**From:** Katie Kurek [REDACTED] **On Behalf Of** CCD Planning Consultations  
**Sent:** 02 October 2018 10:47  
**To:** Planning.Responses  
**Cc:** Zac Denton  
**Subject:** RE: Planning Consultation on: EP/127/18/HH

**Site Address:** 81 Sea Road East Preston BN16 1LN

**Description of** Vehicular access over pavement & aggregate driveway to

| <b>SUBJECT:</b>                  | EP/127/18/HH<br>Vehicular access over pavement & aggregate driveway to front of property.                                                                                                                                                  |

Drawing Name
Location and Block Plans
Proposed

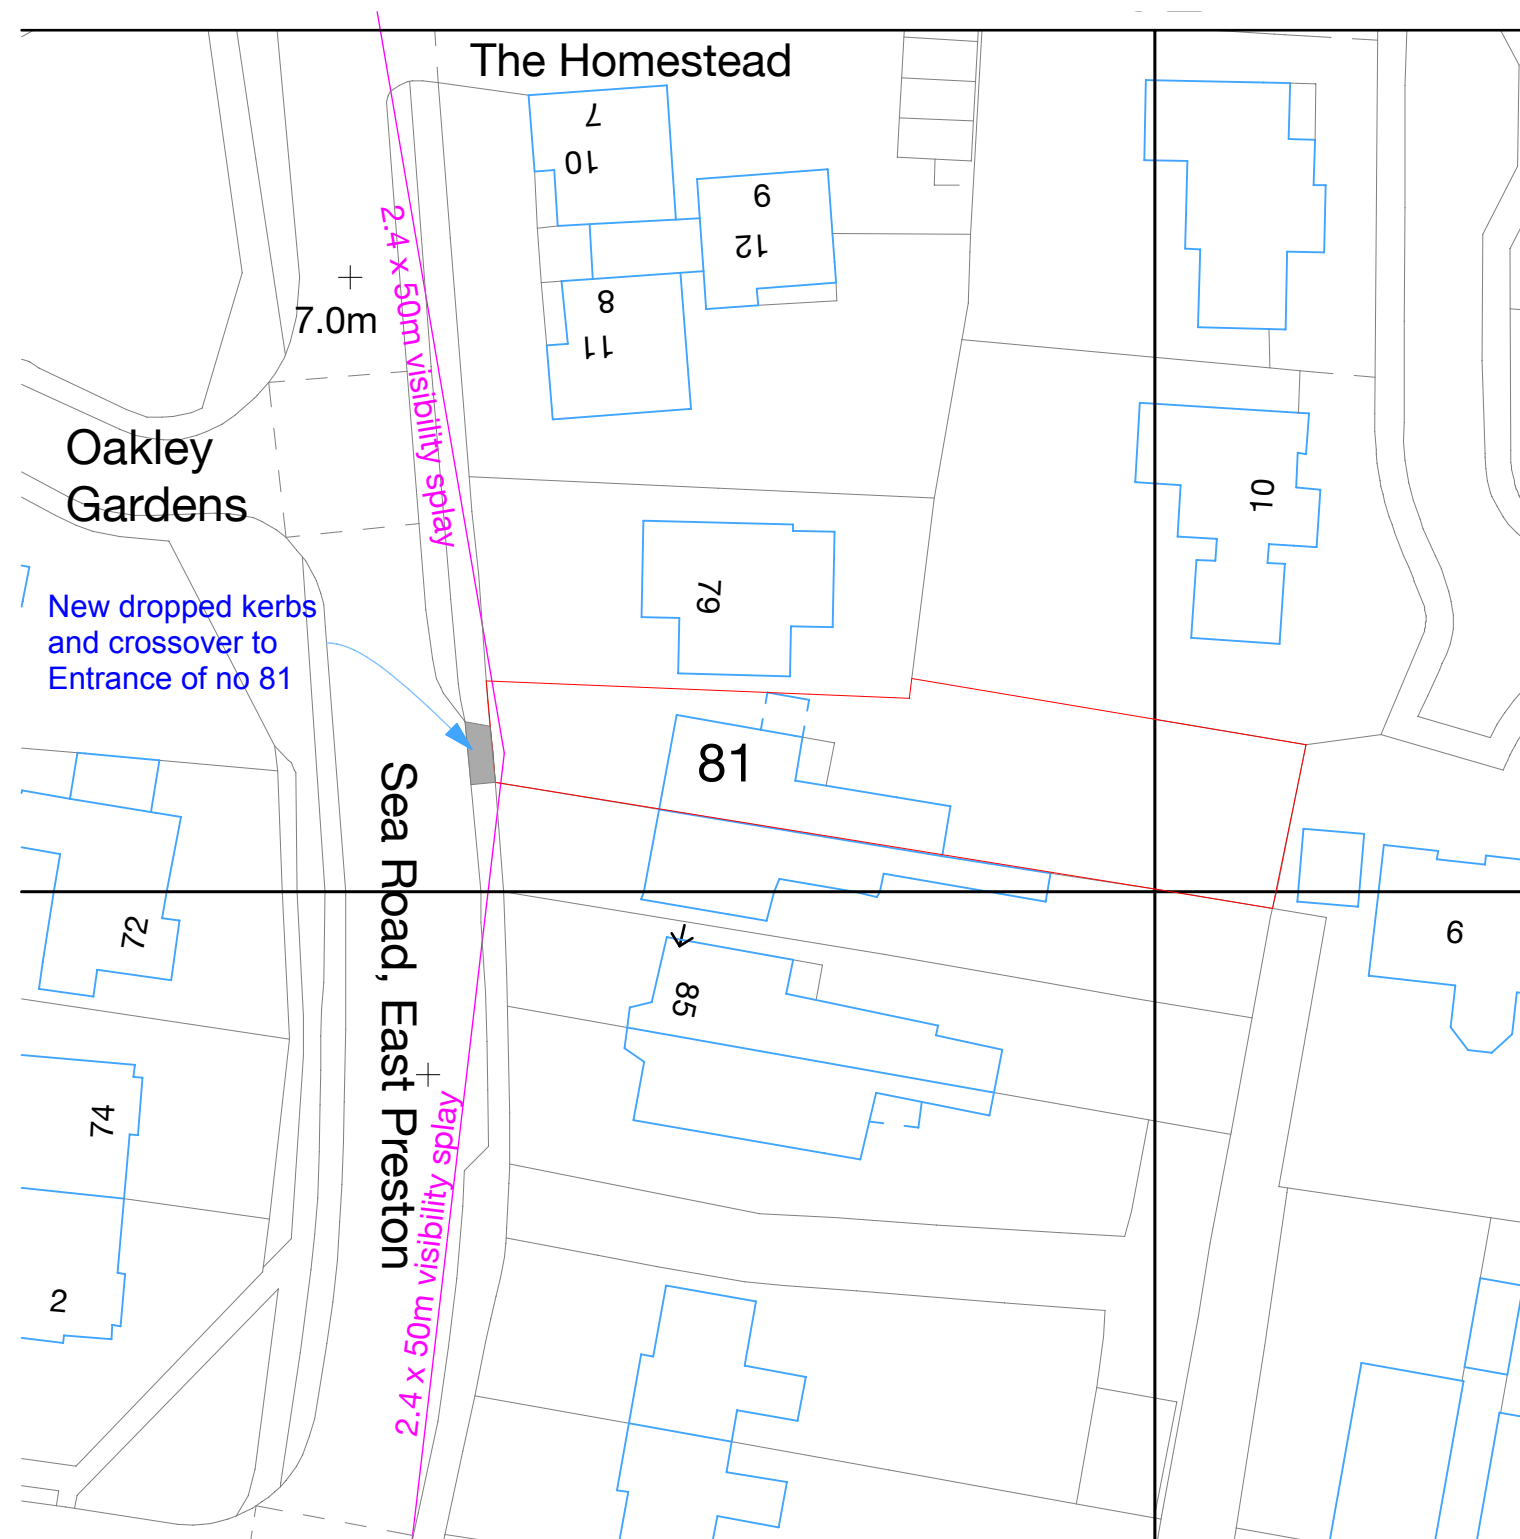
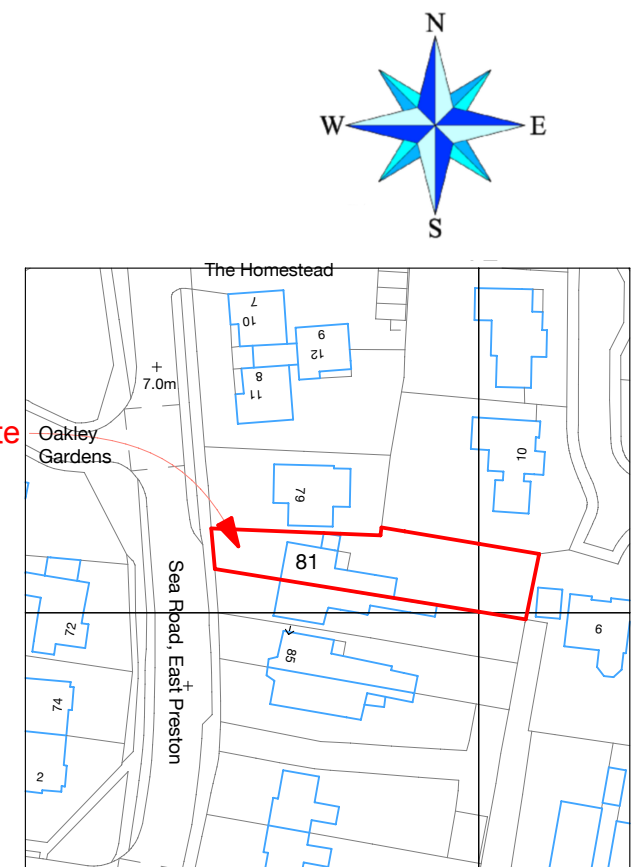
A license to construct the vehicular cross over would need to be obtained from the Arun Area Engineer. It should be noted that a licence at this location is unlikely to be granted due to the Area Office policy that a licence would not be granted for an access through a layby, due to the existing parking pressures and the loss of on-street parking provision for neighbouring residents. It is recommended that the LPA consider the amenity impact of the proposed development should permission be granted.

Visibility splays from 2.4m back into the access have been demonstrated. From an inspection of the plans these pass through neighbouring third party land and could not be maintained in perpetuity. Nevertheless the LHA are mindful that the presence of the layby means the line of cars travelling along the carriageway is in fact further west of the kerb line. When taken from 2.4m back from the line of travel visibility splays of at least 43m (as per Manual for Streets guidance for vehicle speeds of 30mph) are achievable entirely within the publically maintained highway and would therefore not require to be secured via condition.

Whilst visibility along the street edge is restricted by on-street parking, paragraph 10.7.1 of Manual for Streets 2 states that *Parking in visibility splays in built-up areas is quite common, yet it does not appear to create significant problems in practice. Ideally, defined parking bays should be provided outside the visibility splay. However, in some circumstances, where speeds are low, some encroachment may be acceptable.* Similar neighbouring accesses have been operating without evidence of highway safety concern.

It is also evident that there is sufficient space within the frontage of the dwelling for off-street parking without over-hanging the footway. A turn on site would be preferred, clearly though there is insufficient space to achieve this. However other properties have similar arrangements that have been operating without evidence of highway safety concern.

On balance the LHA could not substantiate highway safety grounds to resist the proposal. If the LPA are minded to approve, the following informative should be included:
